Job No. 17-007  
August 02, 2018  
Rev:12-06-18

**LETTER of INTENT  
OBERLE VACATION and REPLAT**

OBERLE VACATION and REPLAT

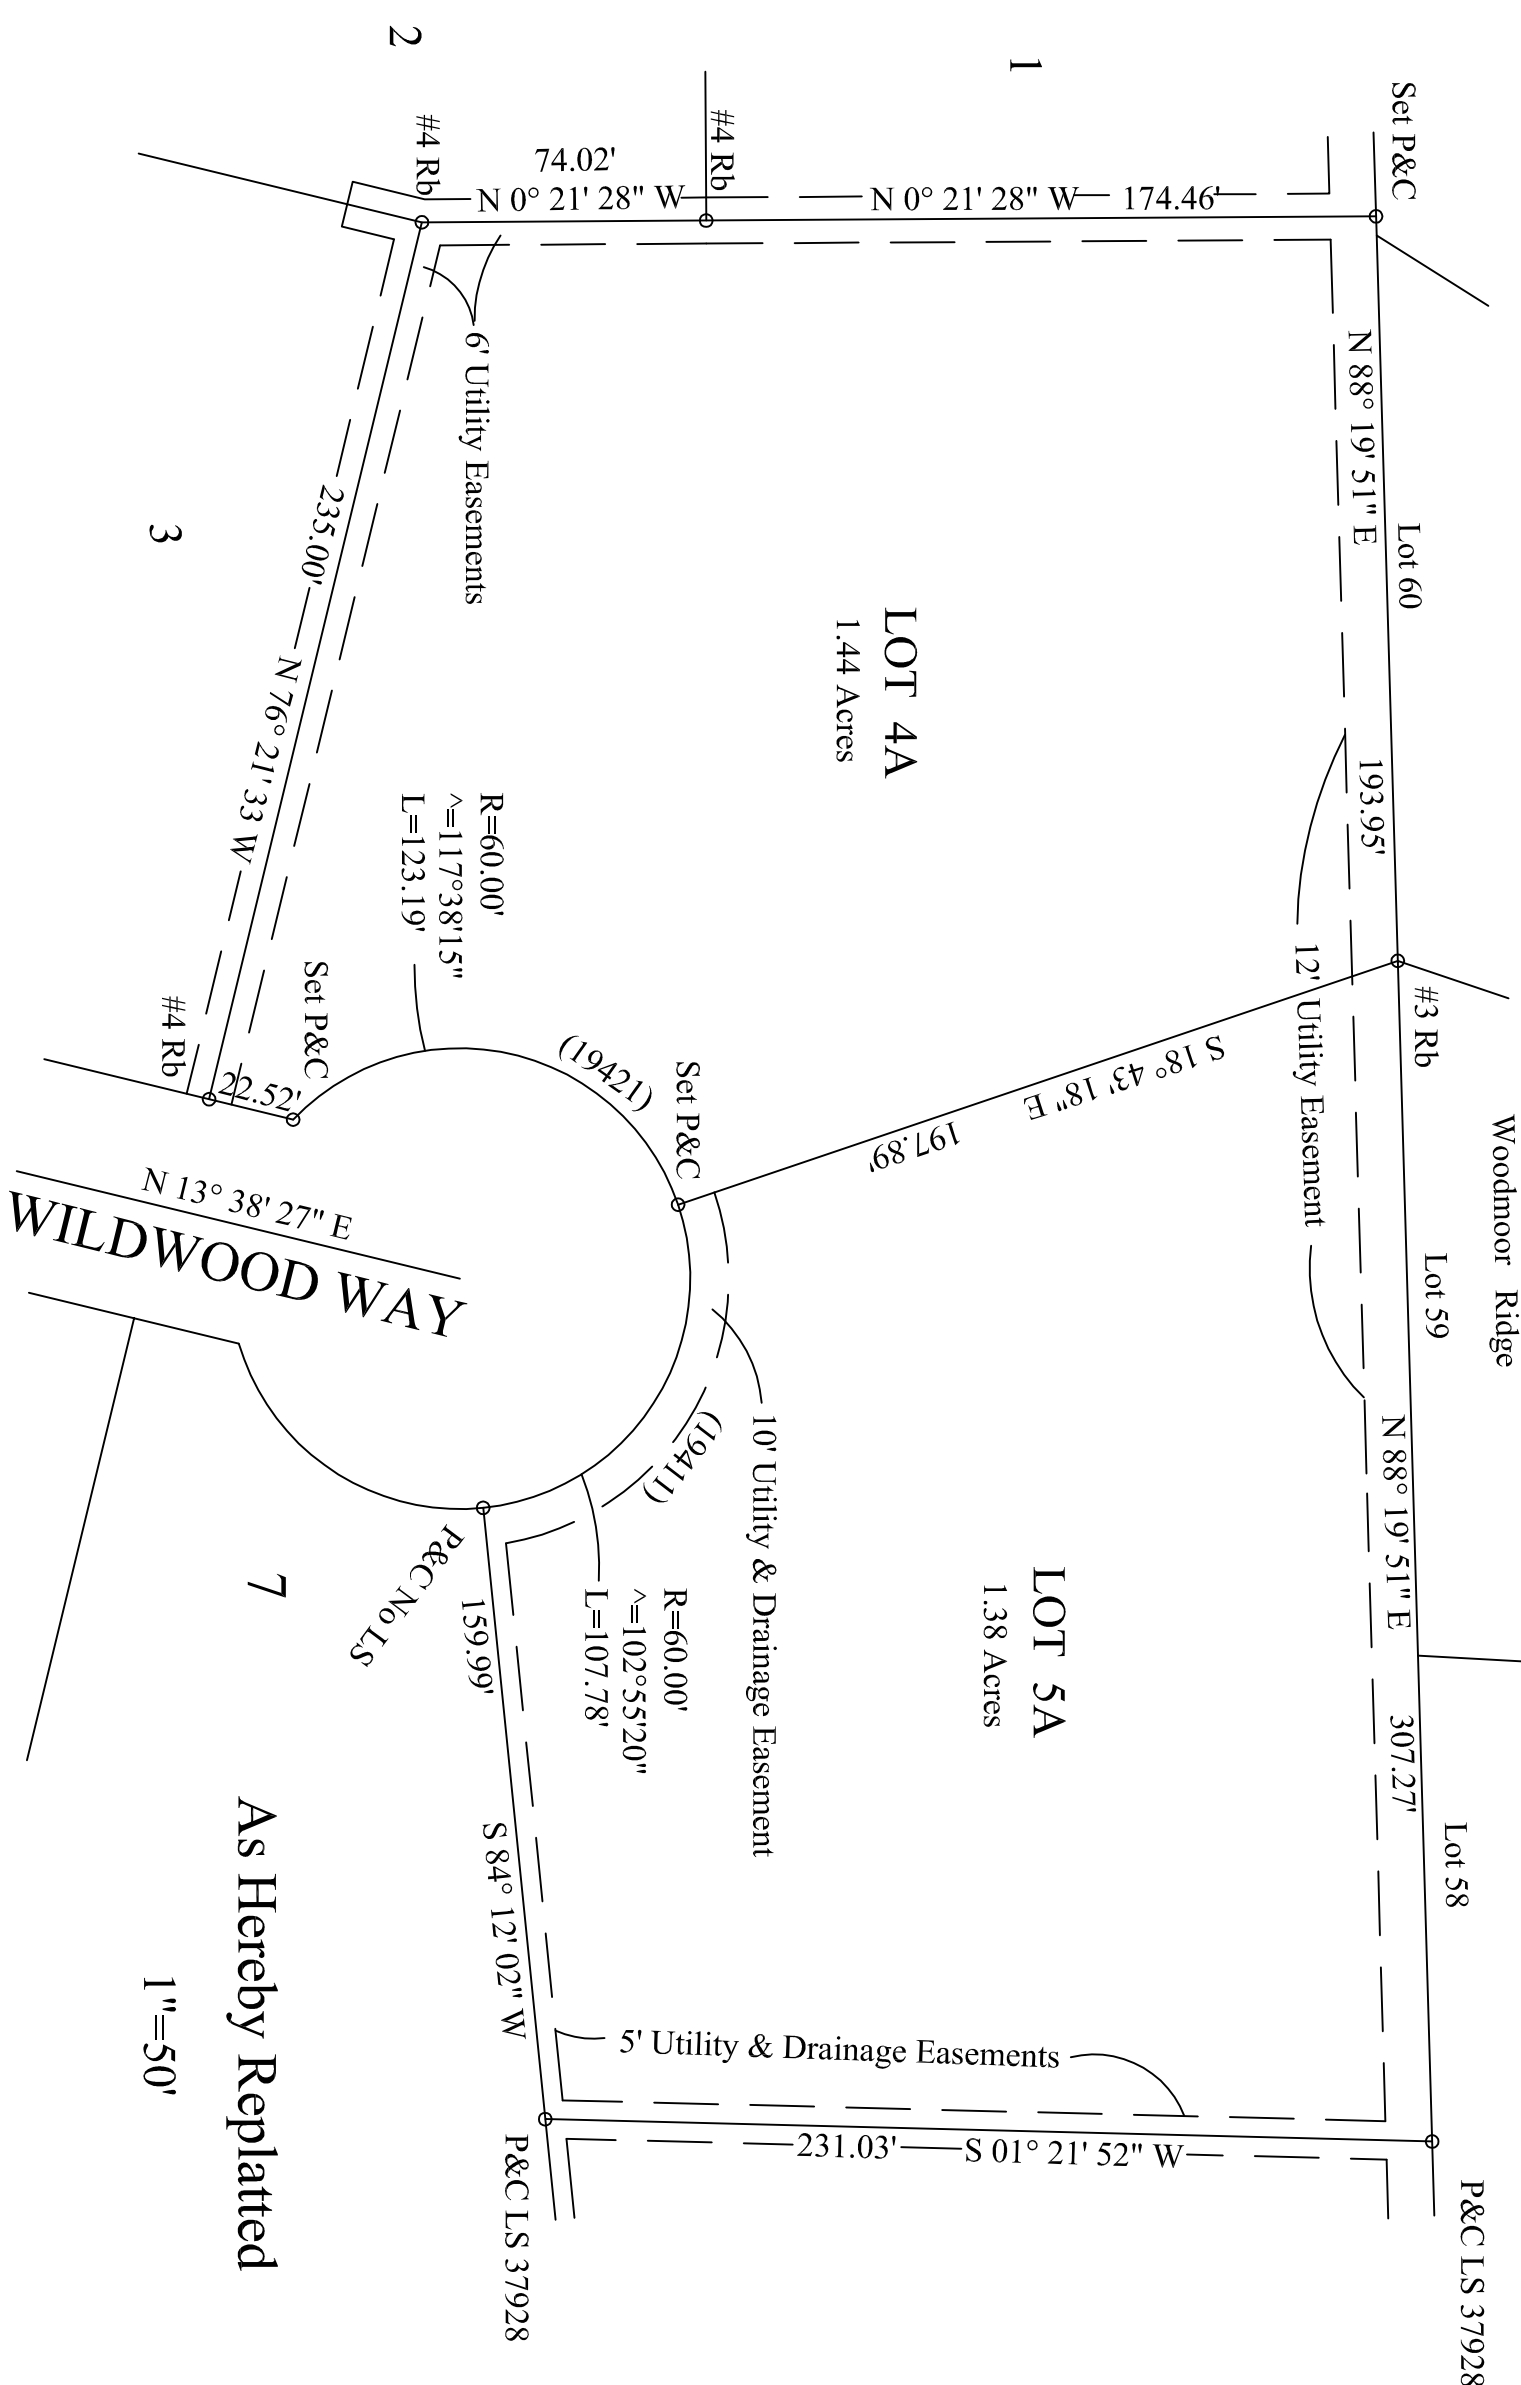
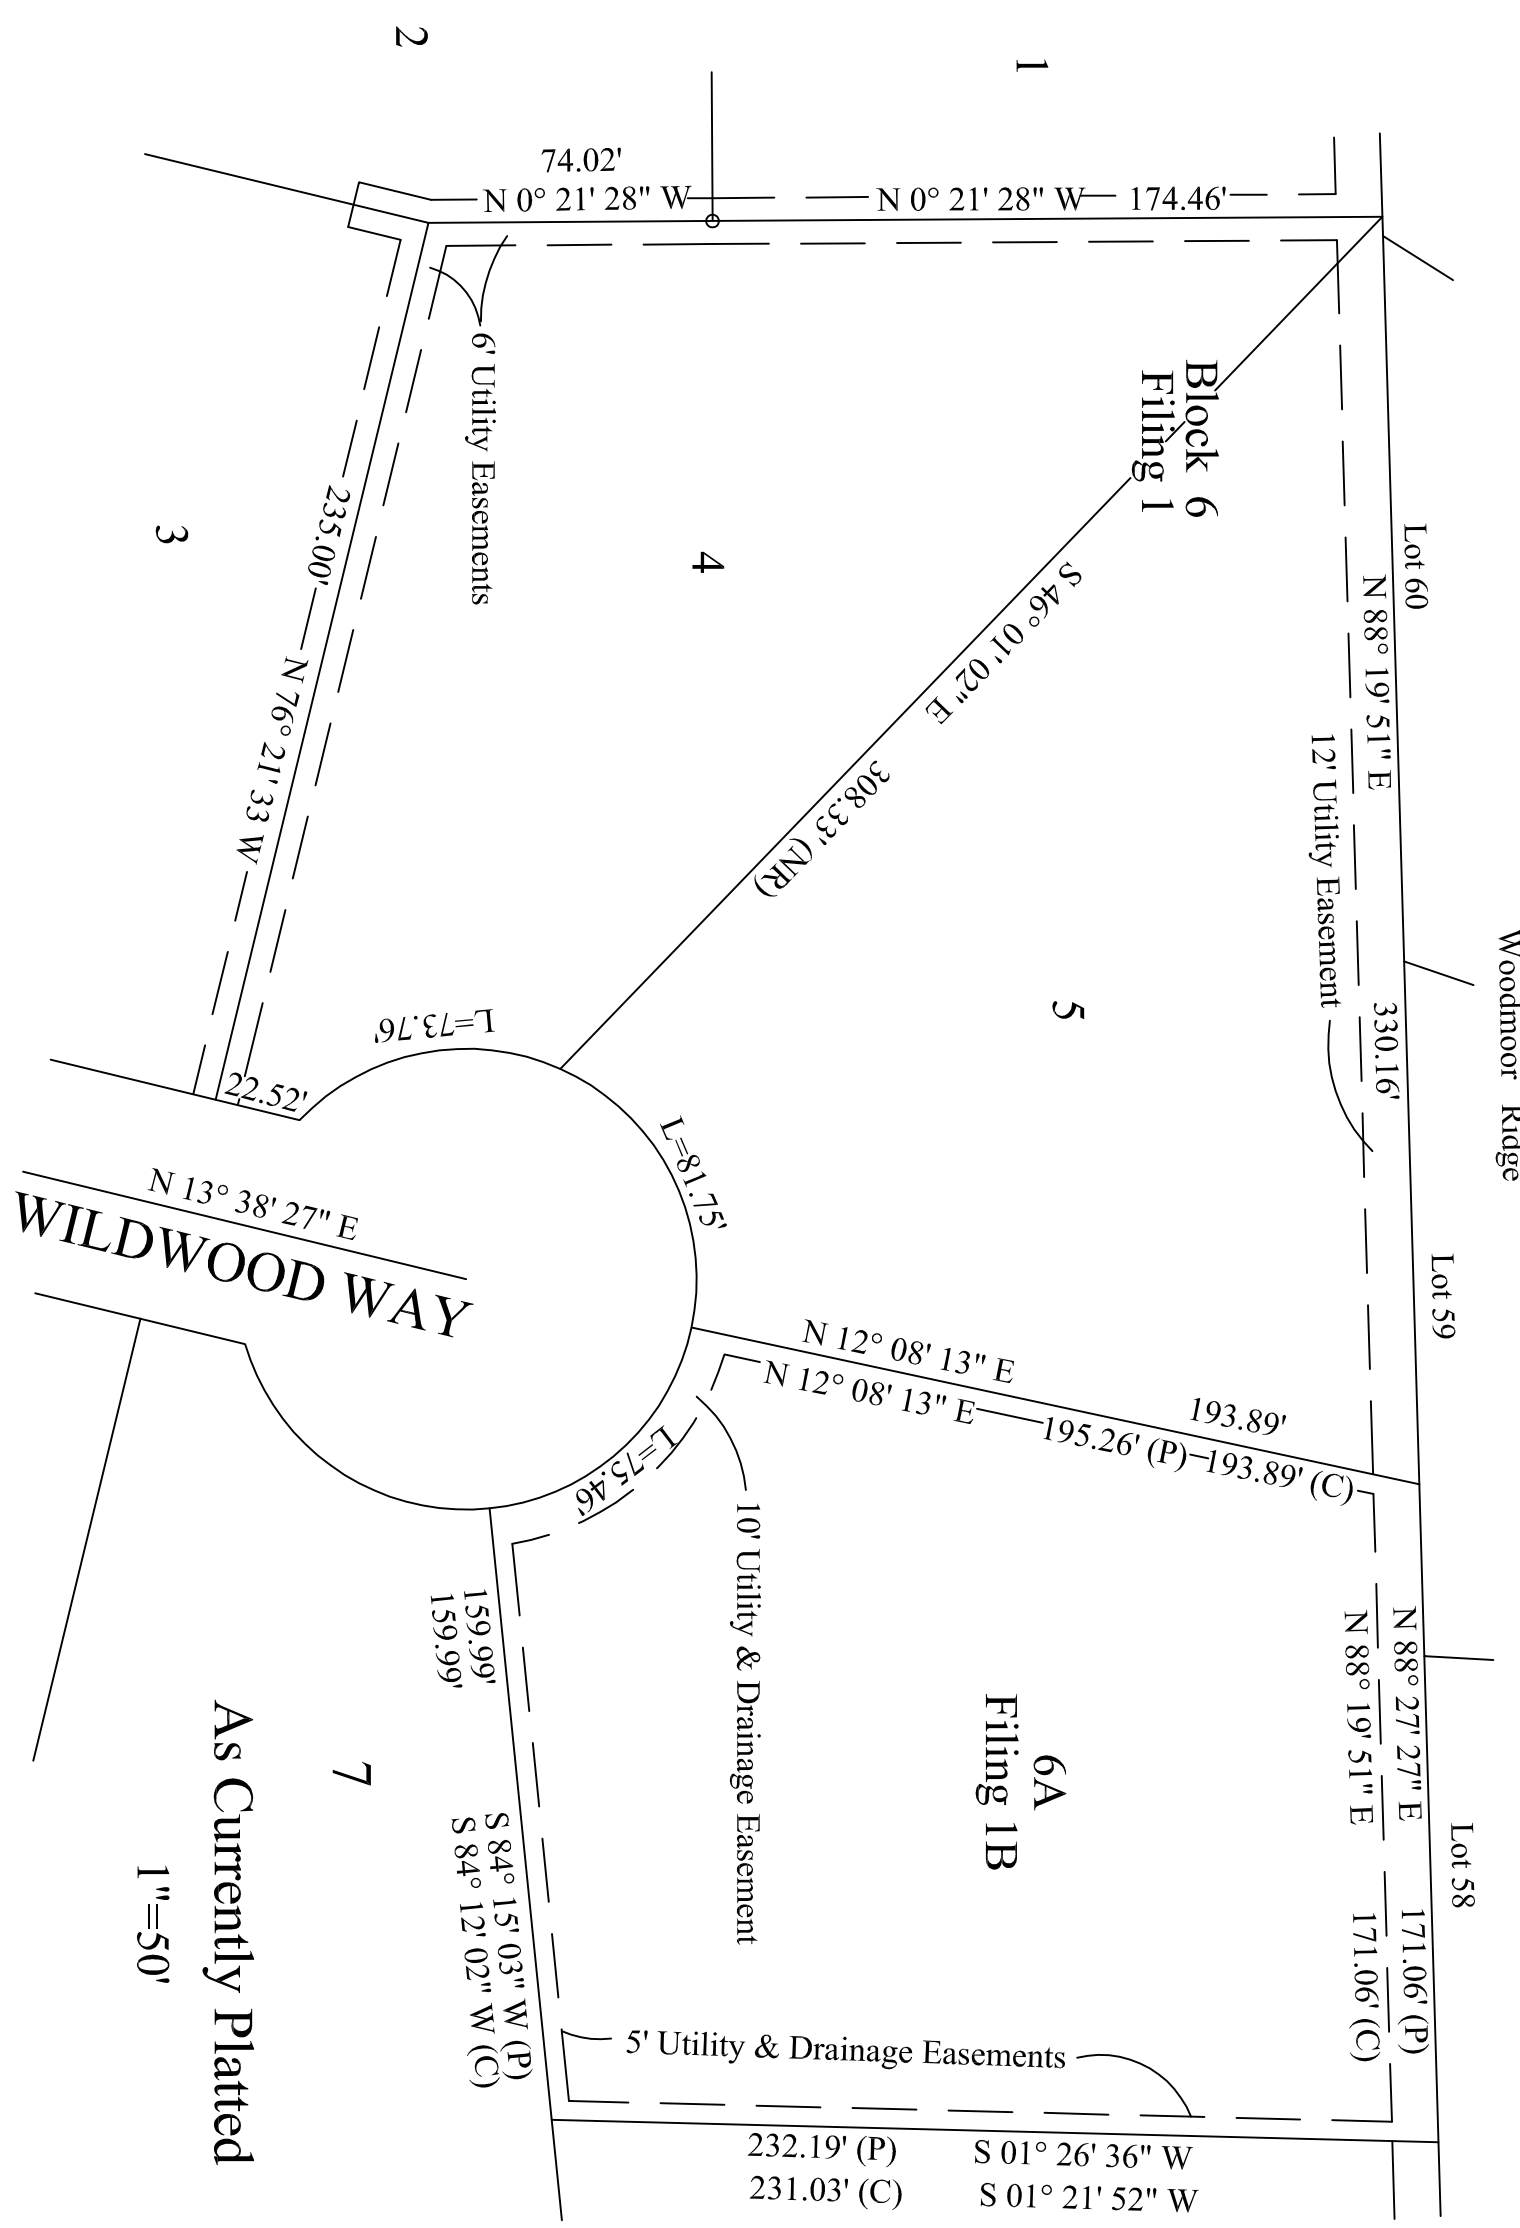
Add this information as notes on the plat.

Add this information as notes on the plat.
